From: Amanda Scholes on behalf of Planning.Responses
Sent: 10 June 2020 08:37
To: Planning Scanning
Subject: FW: EP/48/20/DOC- Site Levels Condition 13
Attachments: 1681 - 16 Worthing Road - 3.01A - Ground Floor GA.PDF

Subject: EP/48/20/DOC- Site Levels Condition 13

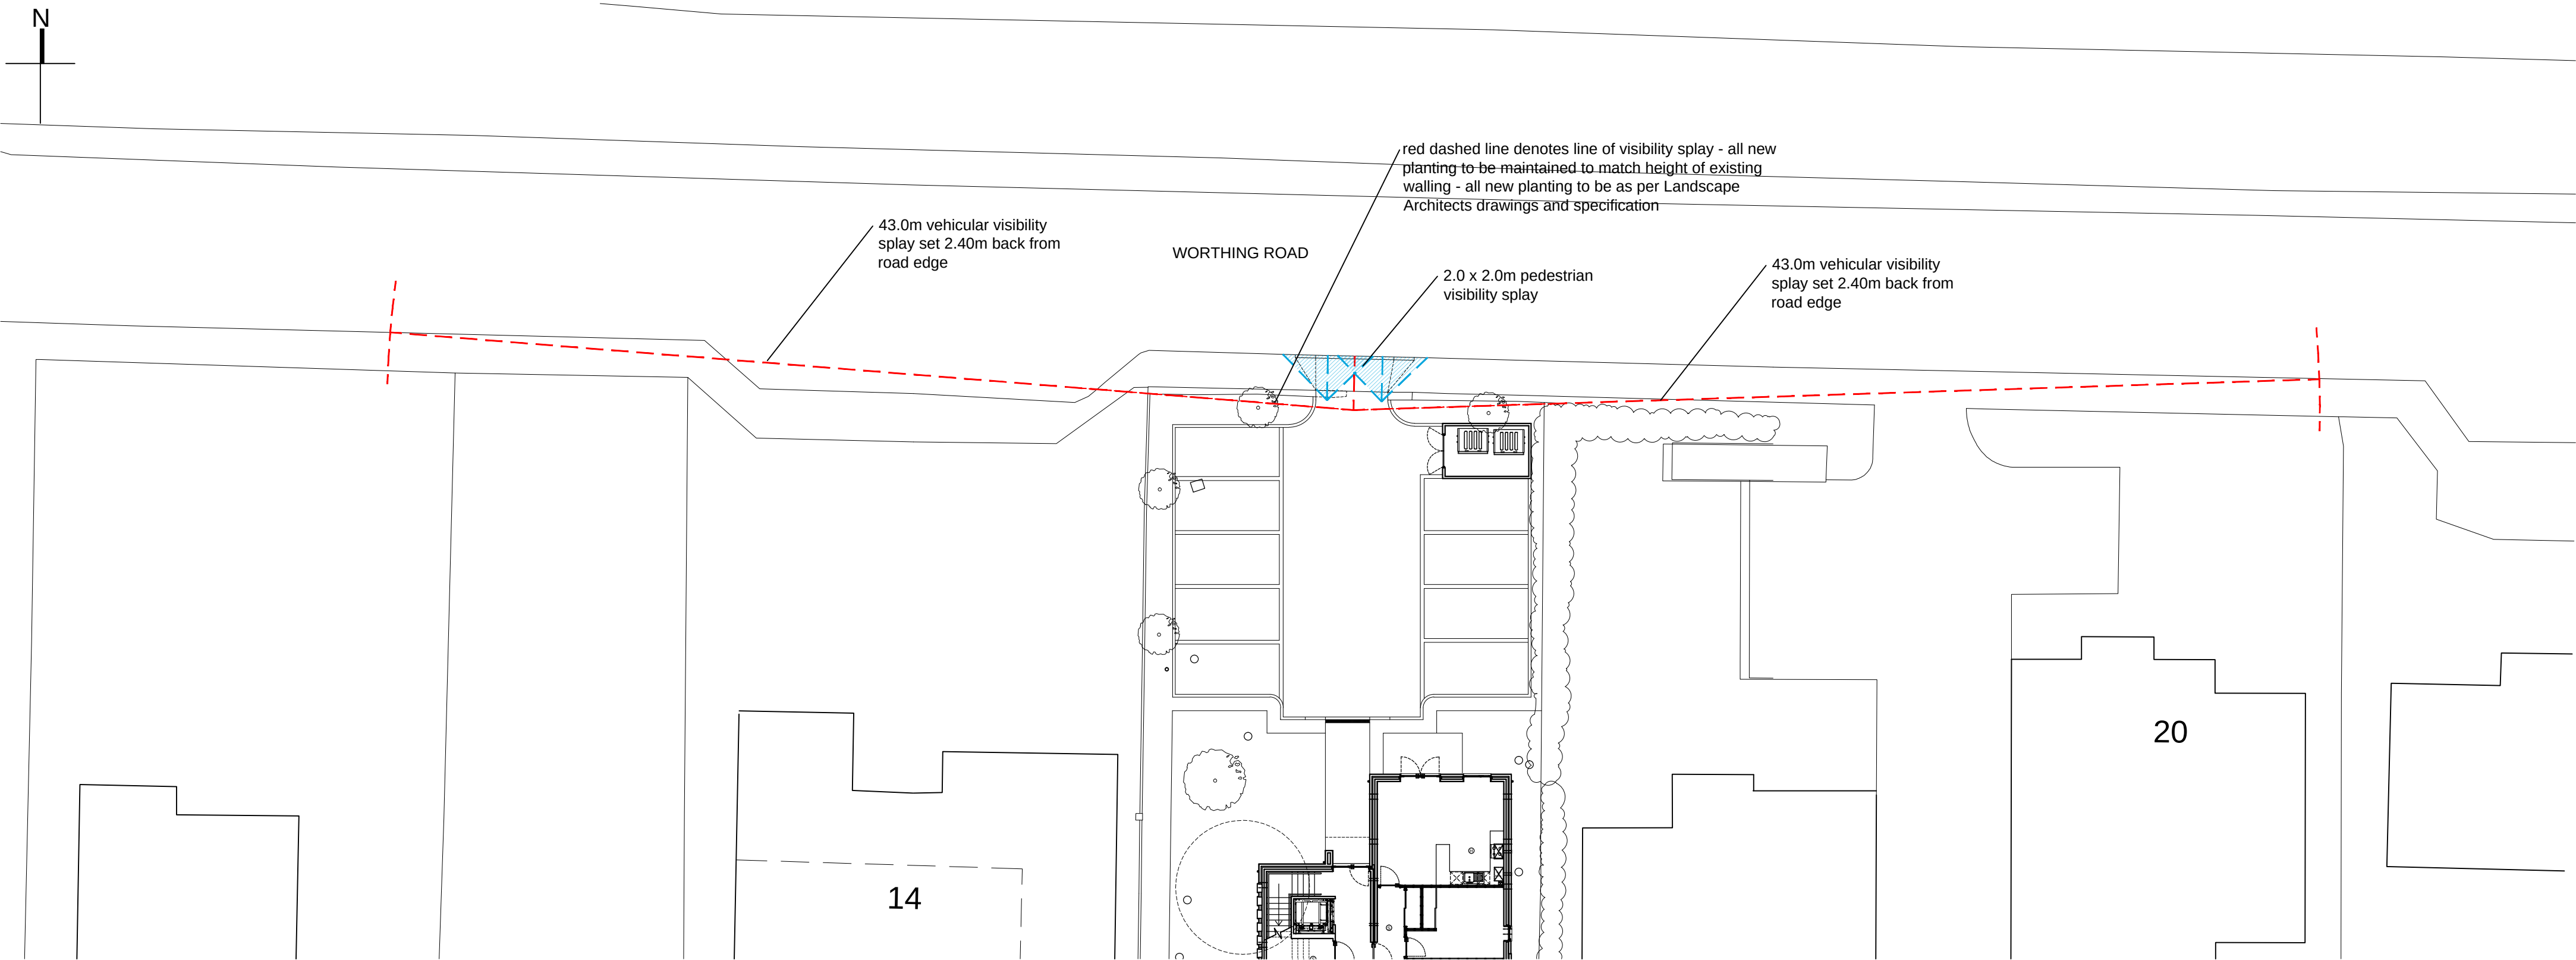
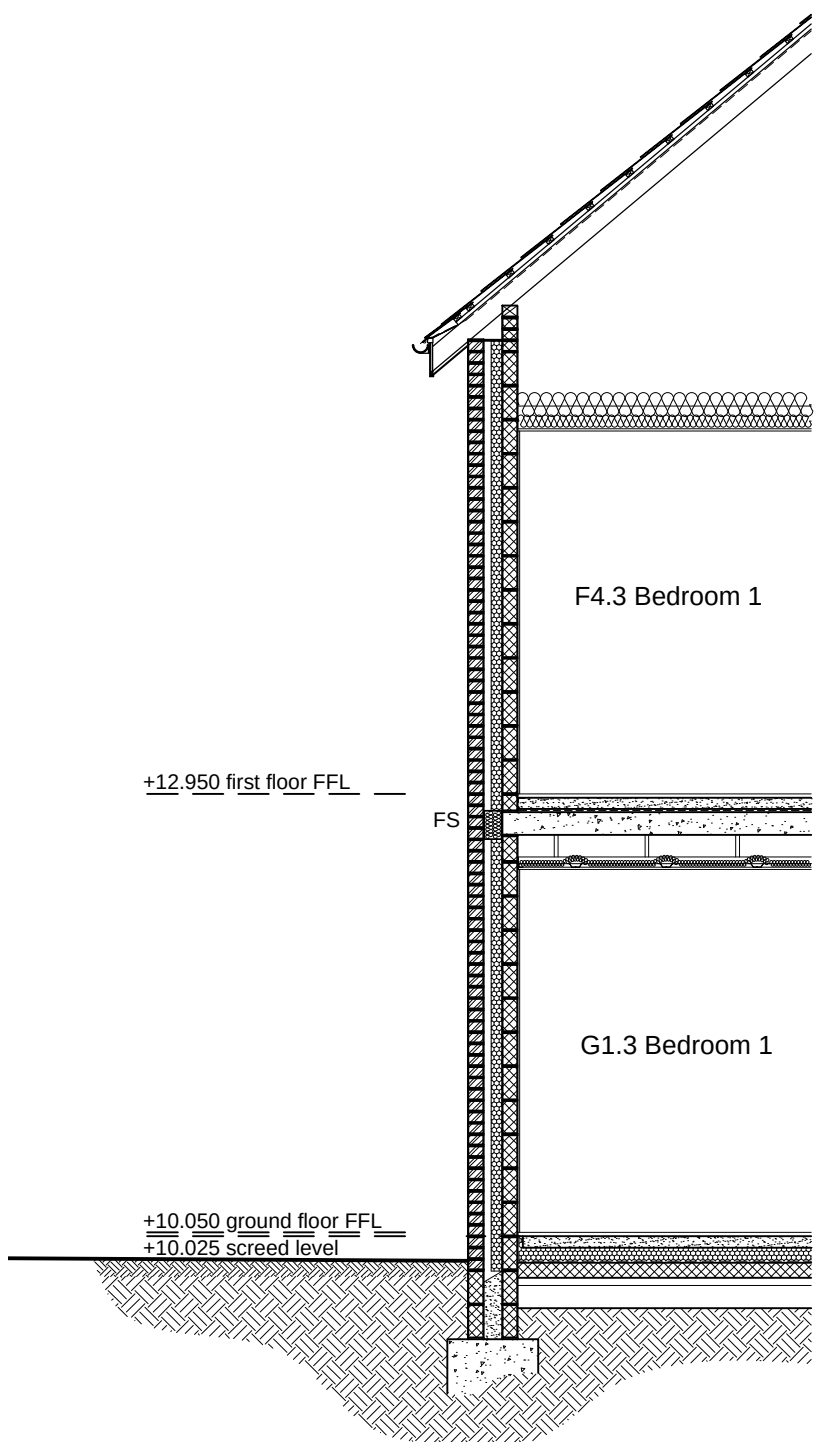
What about the rear section of the site? Do you have any other detail on proposed site levels for this part of the site?

Condition 13 requires submission of existing and proposed site levels. I can only find a topographical survey relating to existing, nothing for proposed. Can you let me have these details within the next 7 days please or the discharge of the condition will be refused based on the submitted details. I apologise that I hadn't noticed this sooner.

The proposed levels are indicated on the submitted drawing no.3.08 – External Works Layout – copy attached – please let me know if you require any additional information.
